CITY OF ALBUQUERQUE

September 12, 2019

Re: New Office Building
10601 Research Rd SE
Traffic Circulation Layout
Engineer's/Architect's Stamp 08-21-19 (M21-D021)

TRAFFIC CIRCULATION LAYOUT

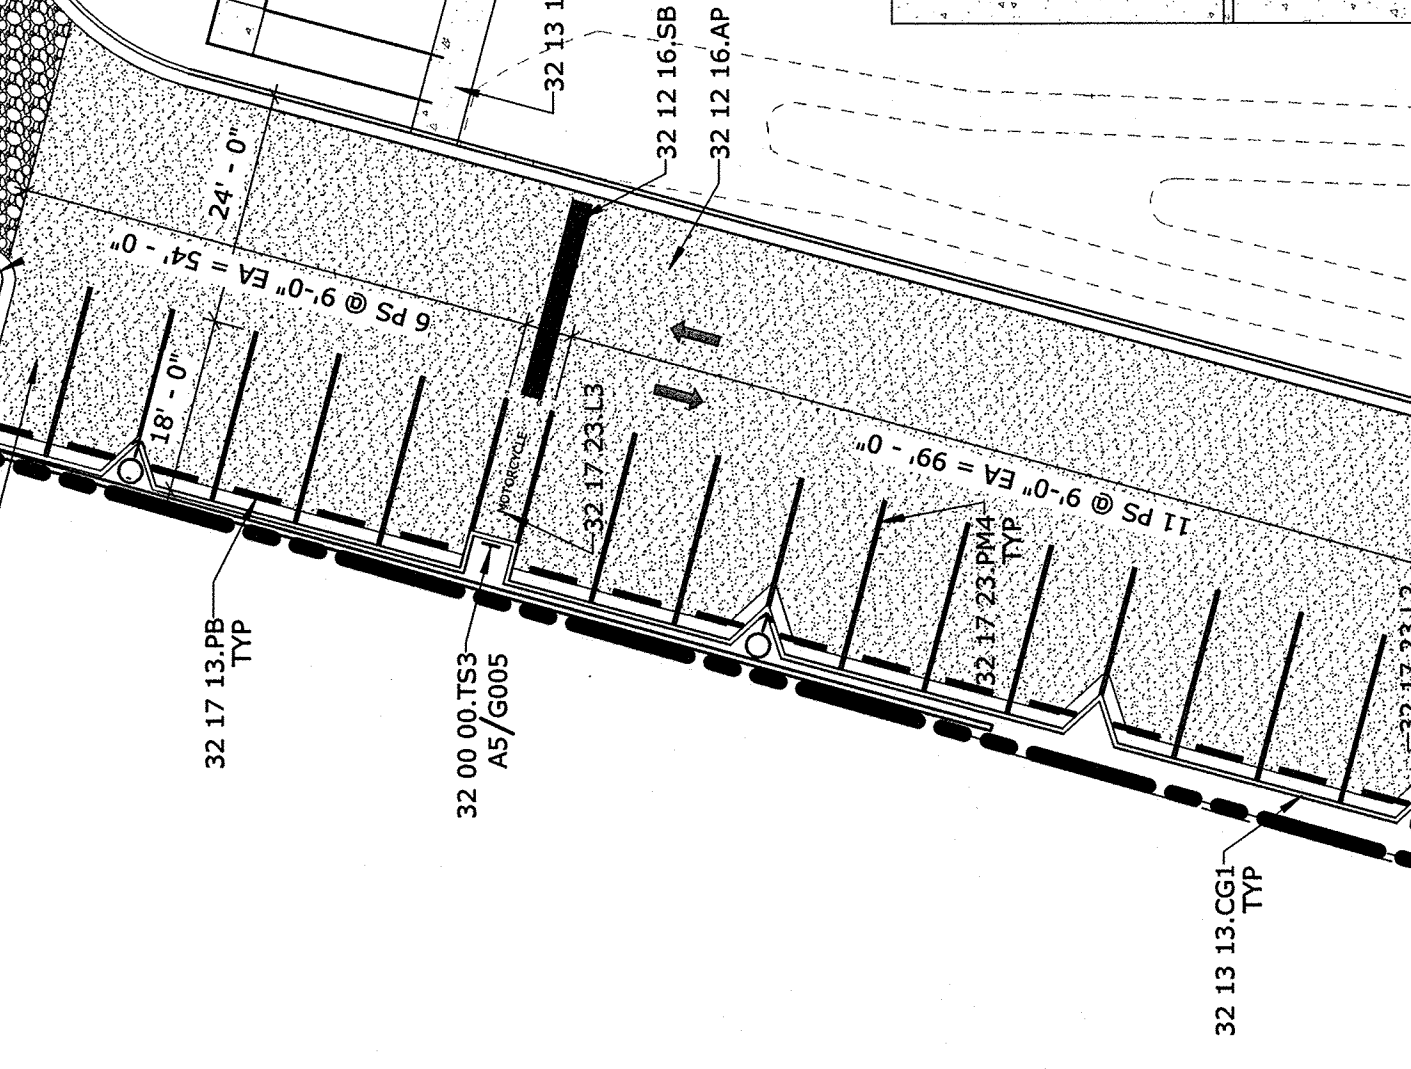
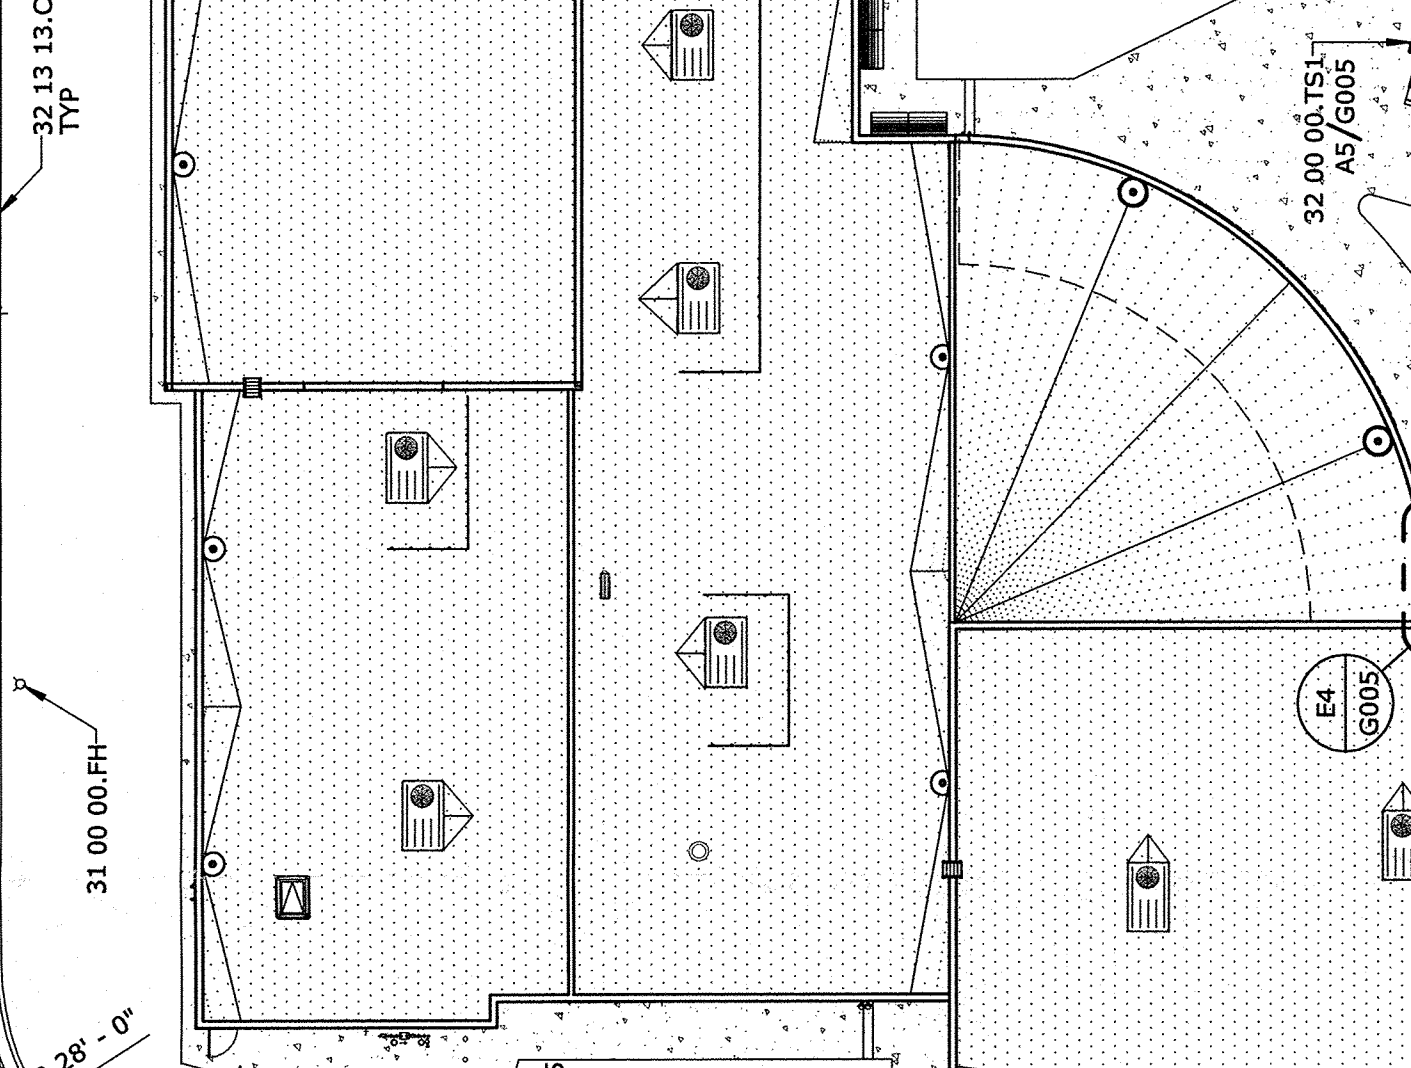
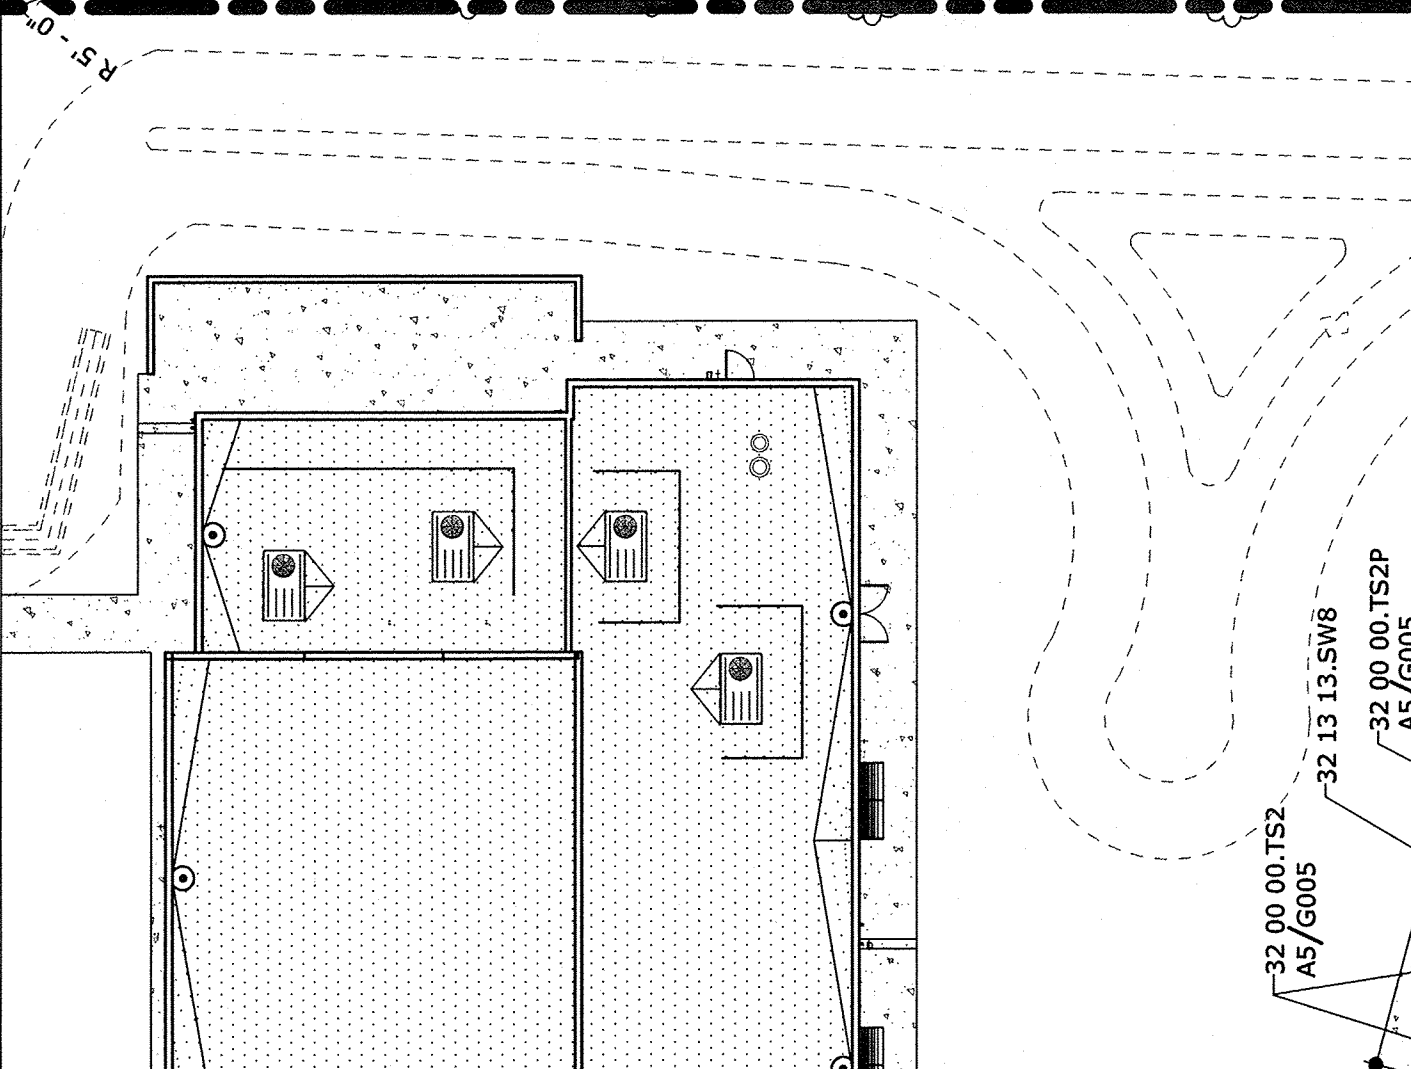
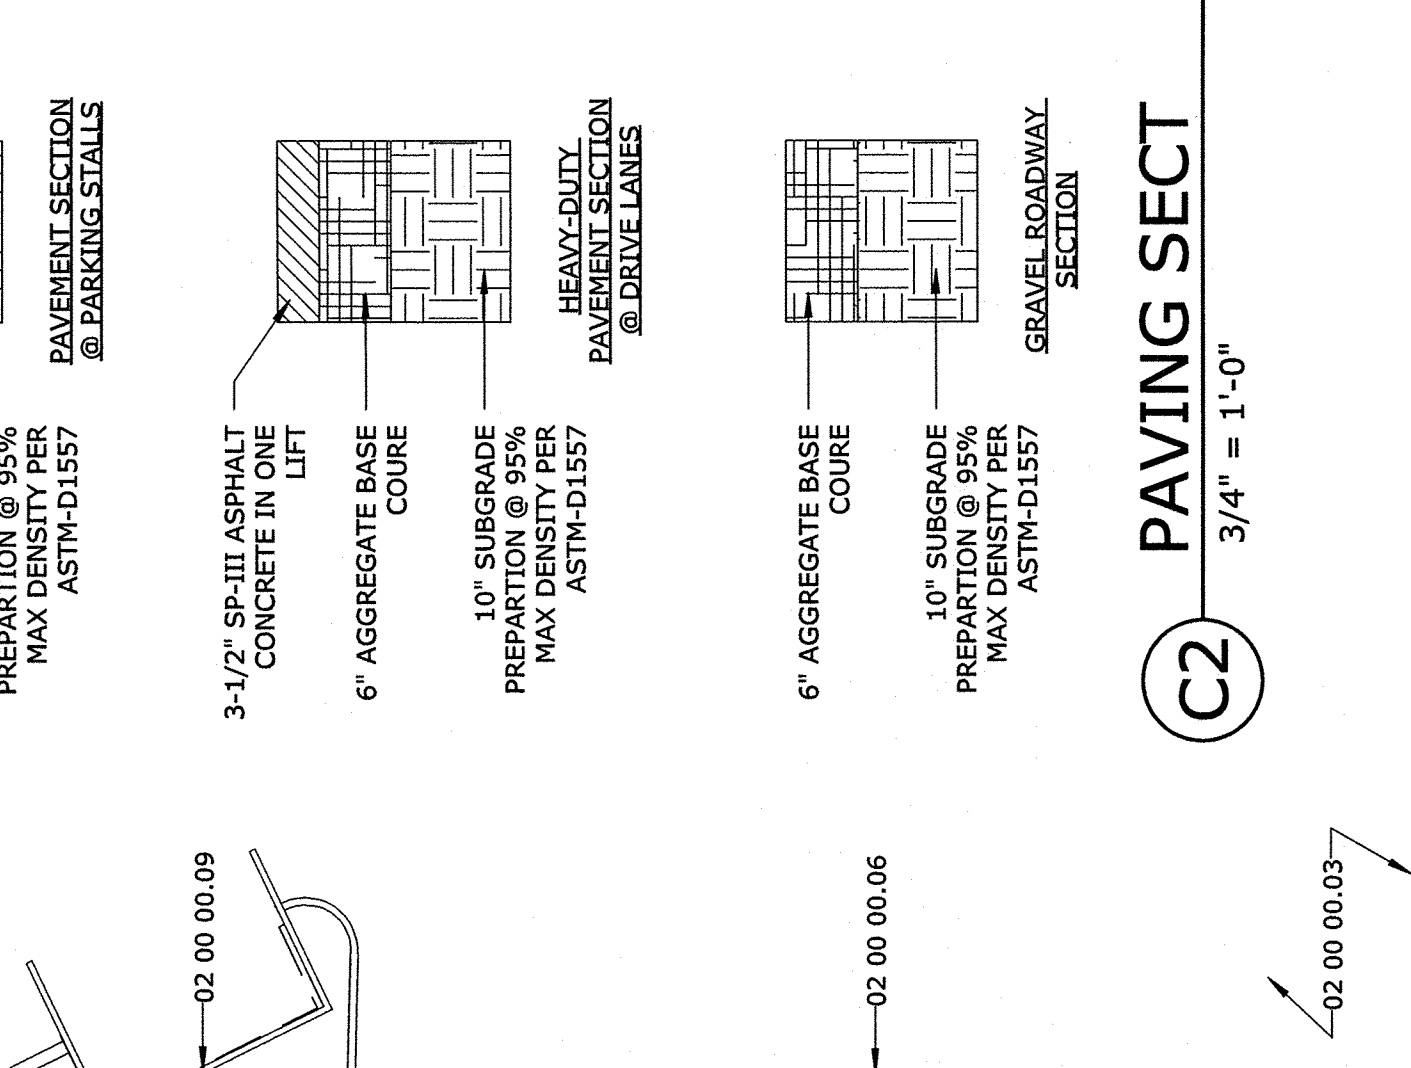
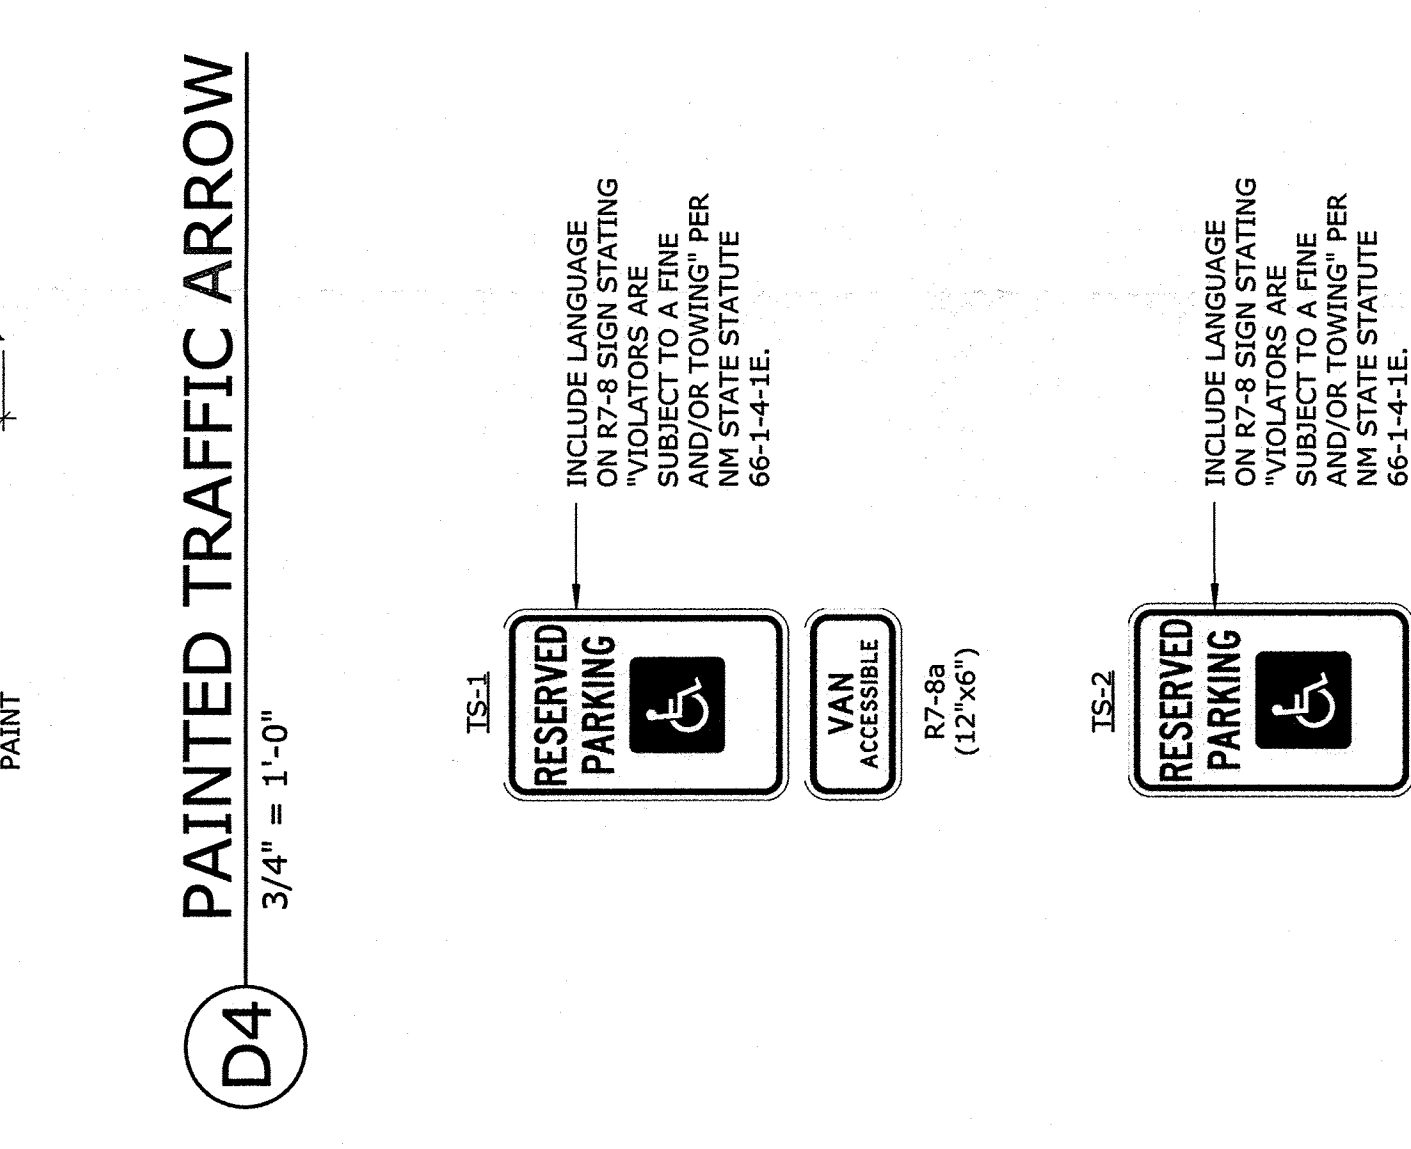
1. The number of parking space provided is less than required. Please send me the result of the variance review before I can approve the TCL.
2. It is not apparent what type of pavement surface is being proposed. A hard driving surface will be required as part of this proposed project for parking area and drive aisles. **Please show a detail of the type of pavement.**
